Your ref: 3/2017/0079

Date: 8th February 2017

Planning Application 3/2017/0079: Proposed structural works to west facing gable end of building to include lateral restraint and associated remedial building works; Hark to Bounty Inn, Townend, Slaidburn BB7 3EP

Drawing title
Proposed Plans and Elevations

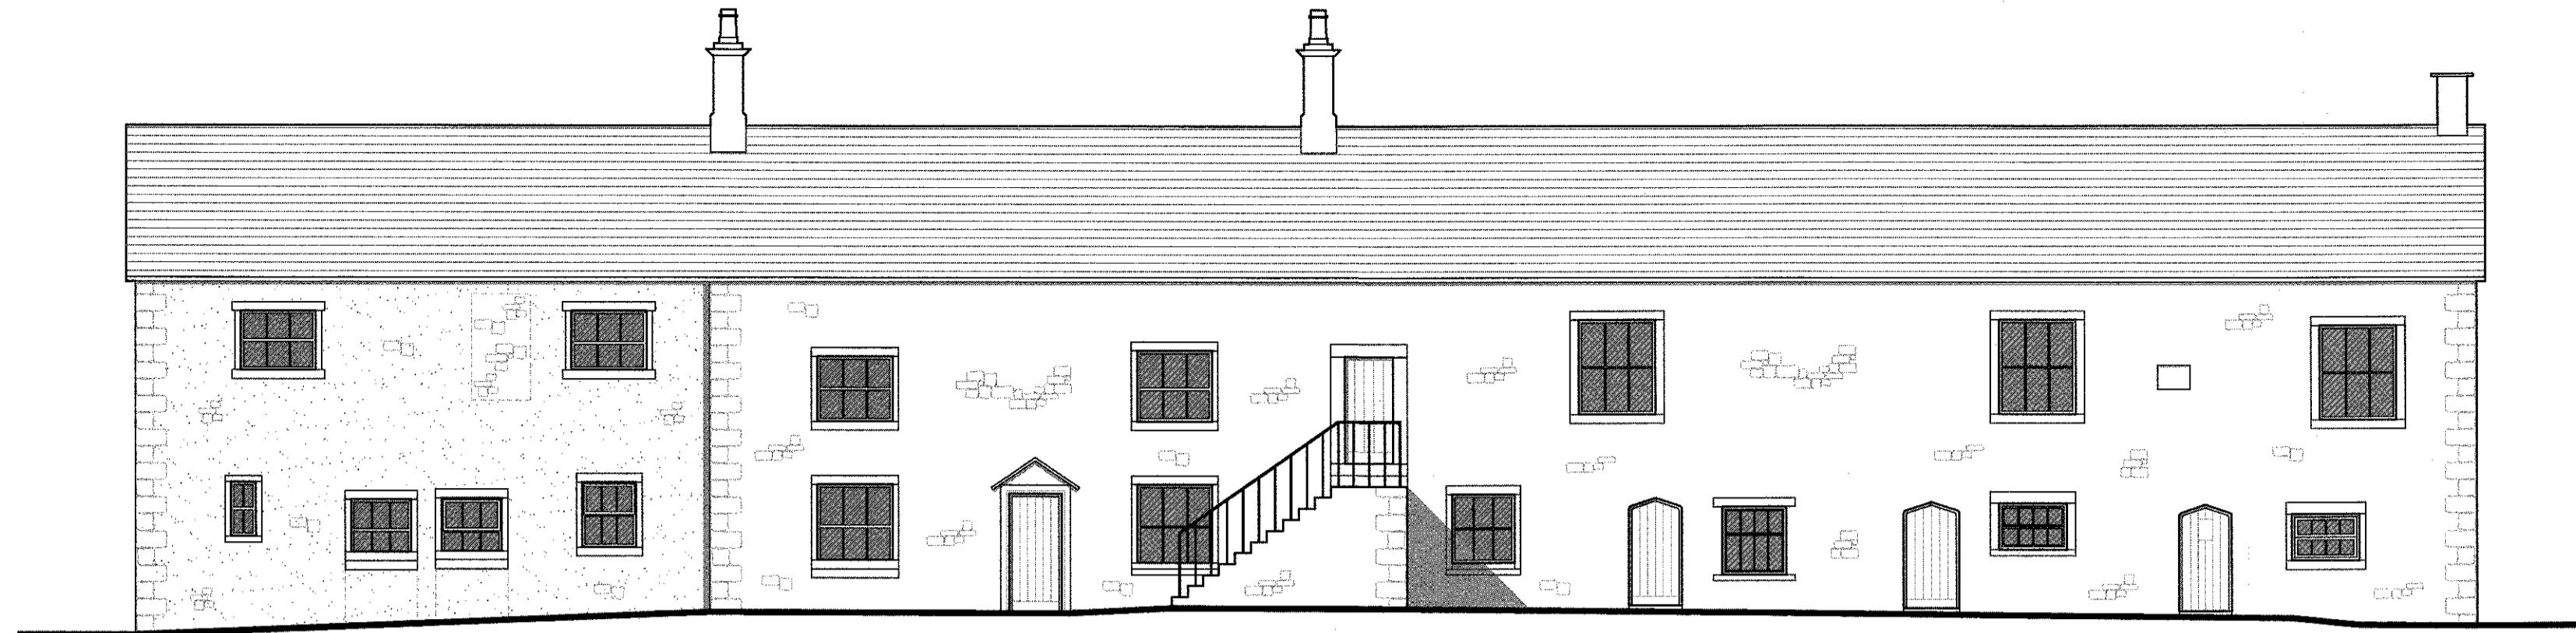
As long as the repair work is limited to the gable wall itself, we would have no objection to the scheme in principal, but would note that there are no detail drawings provided, particularly for the existing and proposed opening, quoins and eaves.

If the proposal is to rebuild like for like, retaining all quoins, window surrounds, etc. then this needs to be stated specifically in the application and a note made in the methodology to indicate that such stones will be numbered/recorded, set aside safely and replaced in their original positions.
